**KIRKLEES METROPOLITAN COUNCIL
INVESTMENT & REGENERATION SERVICE**

**DELEGATED DECISION TO DETERMINE APPLICATIONS FOR
NON-MATERIAL AMENDMENTS**

Reference No: **2024/NM/90901/W**

Site Address: Salendine Filling Station, New Hey Road, Salendine Nook, Huddersfield, HD3 3UZ

DRAWING TITLE
 PROPOSED SITE ELEVATIONS
 NON MATERIAL VARIATION APPLICATION

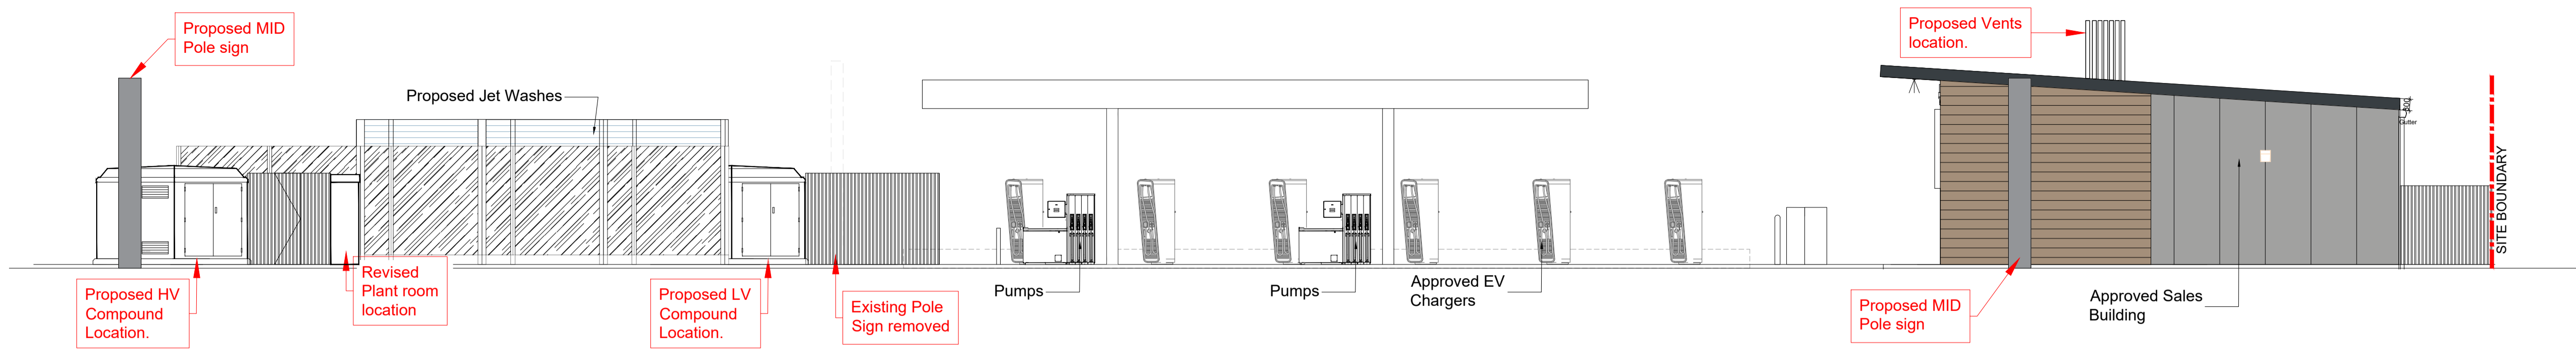
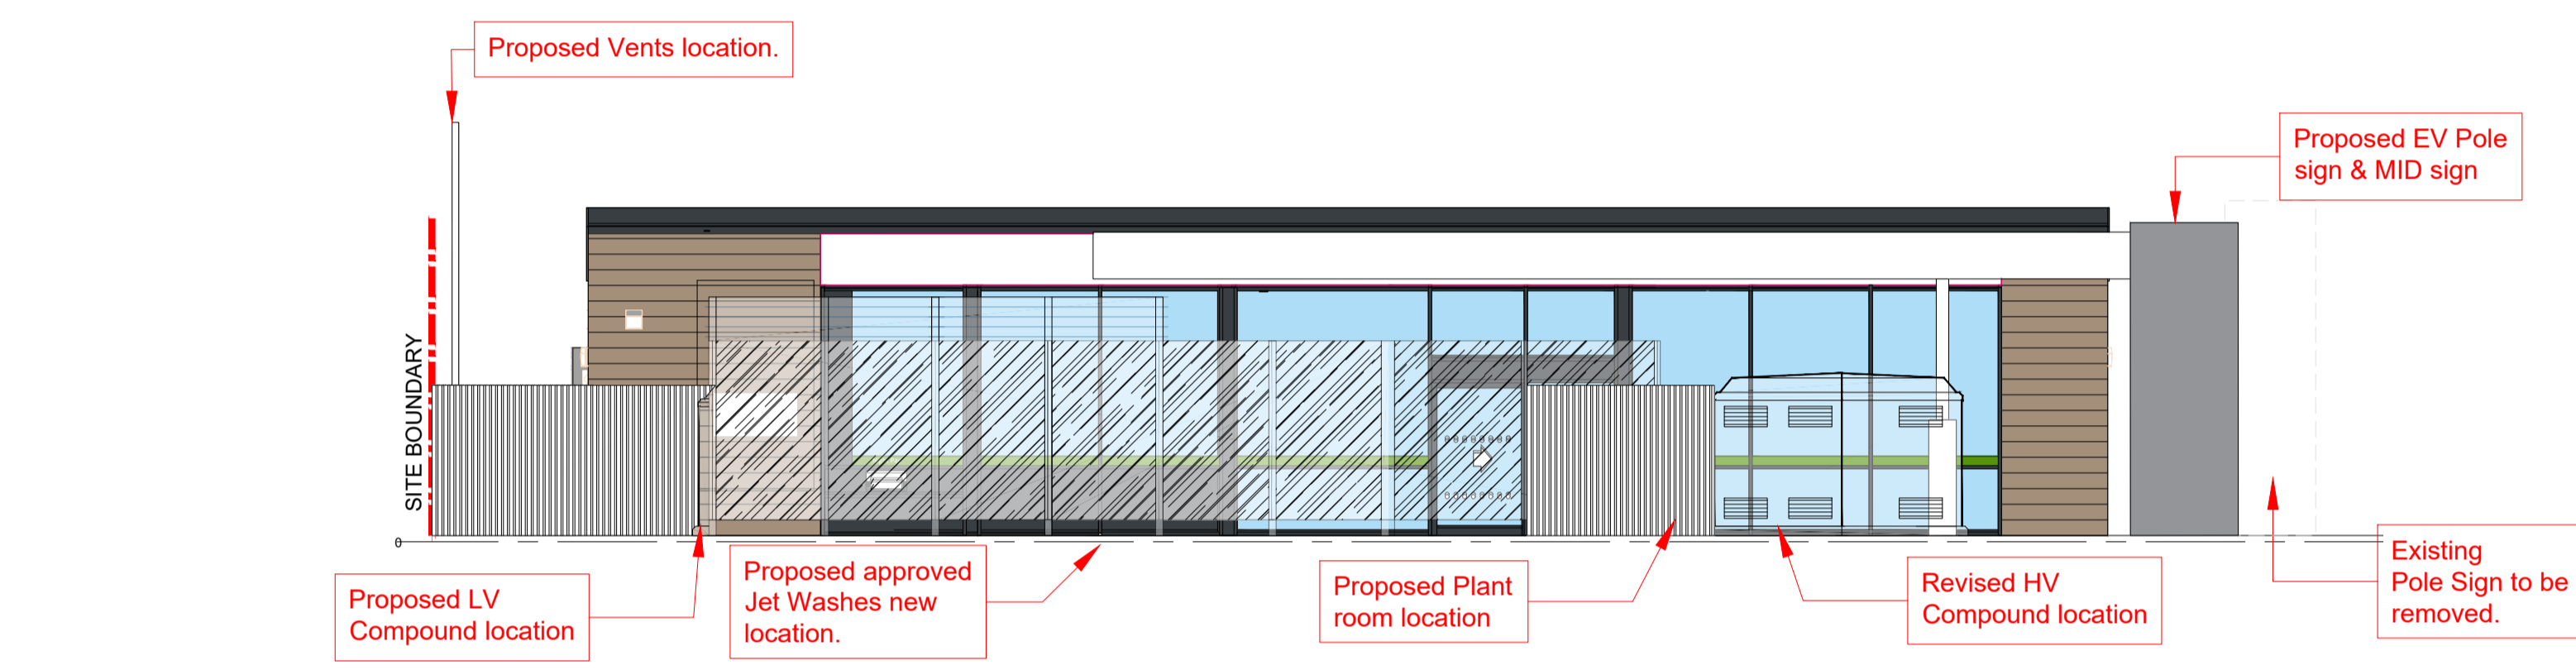
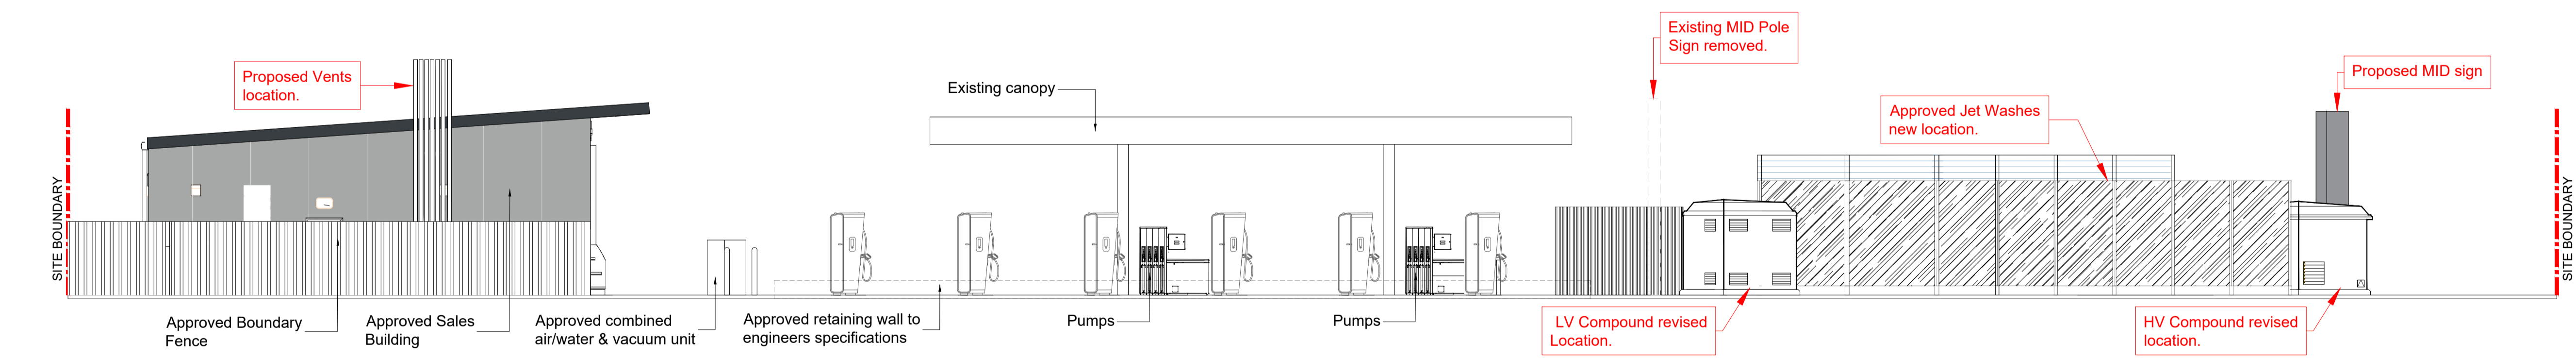
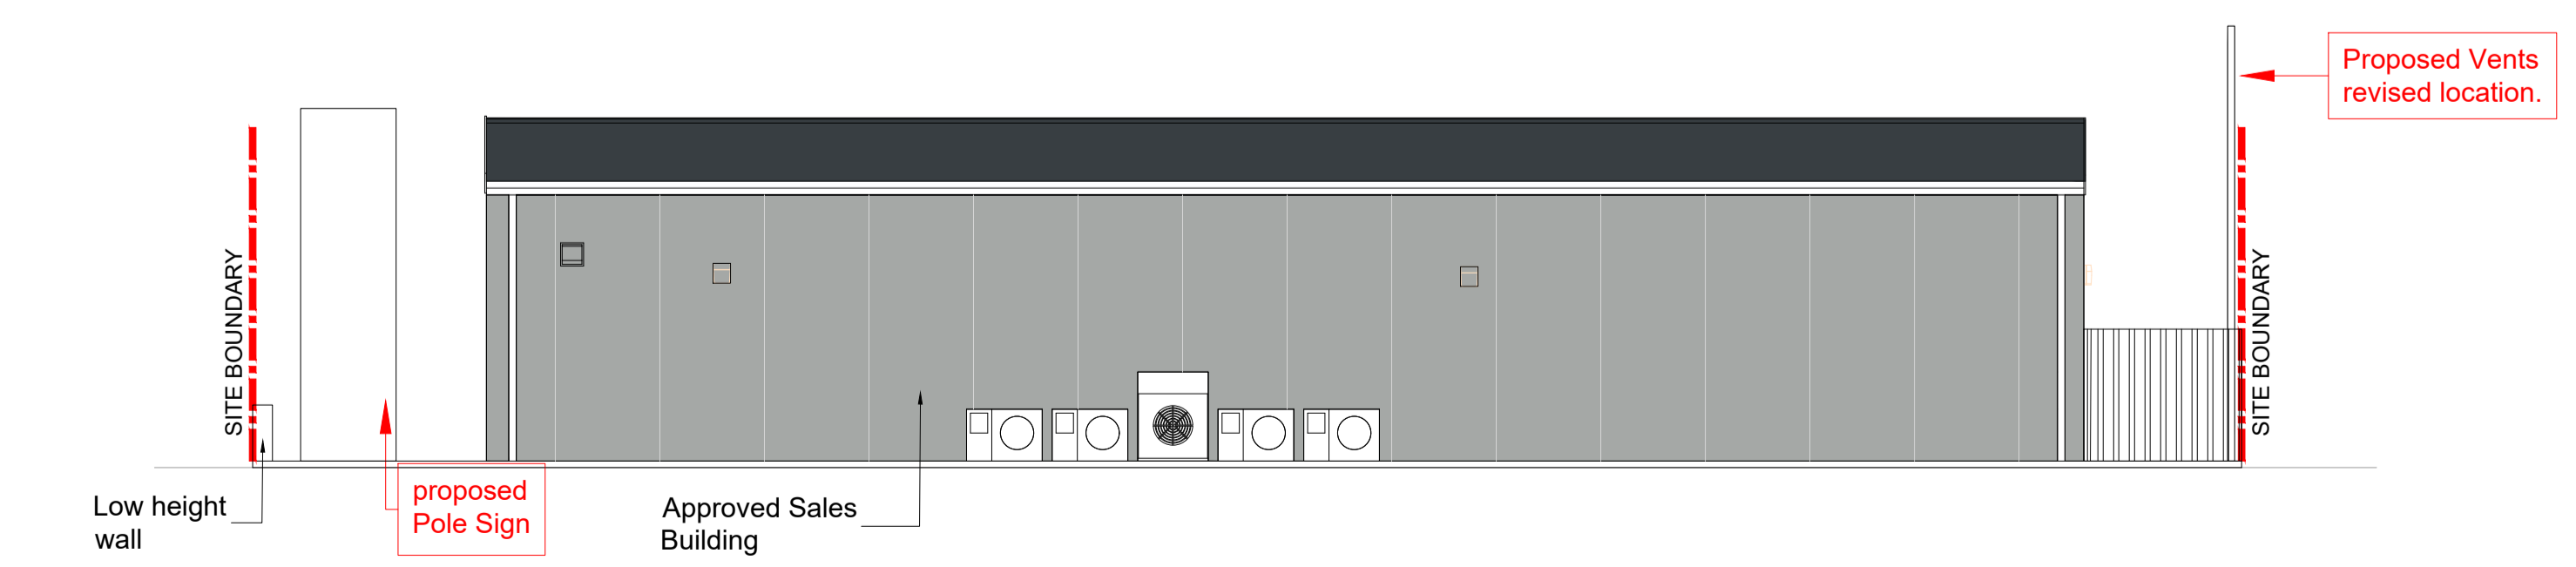
The amendments are required to allow a new proposed location for the 'HV'. The alterations include a revised location for the originally approved jet wash bays, the jet wash bays are to be moved slightly to the south-west approximately 4m from the originally approved position. The originally approved LV Panel GRP enclosure is also to be slightly relocated further north-west into the site, with a new vent stack proposed to be installed along the southern boundary of site, directly adjacent to no. 385 New Hey Road. In addition, the originally approved substation was to be located to the south-west of the 3 new jet wash bays, now the proposals seek to provide the substation to the north-east of the bays closer to the public highway. A metering GRP cabinet is also to be located to the side of this substation (relocated from the original substation location), with 2.4m high hit and miss timber fencing enclosing these structures. Whilst found on the same side of the site, the originally approved plant room is to be moved slightly to the north and does appear to have changed in design/scale and size when compared to the originally approved plans.

- The proposed change would not result in any increase in height, scale, width or depth of a building. – **Whilst the majority of the changes proposed relate to the relocation of buildings and structures rather than an increase to their size, Officers do acknowledge that the originally approved plant room does appear to have changed in design and increased in size and there are material changes to the layout of the scheme.**

The proposed alterations and relocation of jet wash bays, substation, meter cabinet, LV unit, plant room, vent stack and pole (and MID signs which would require a separate application for advertisement consent) within the application site cannot be acceptable as a non-material amendment.
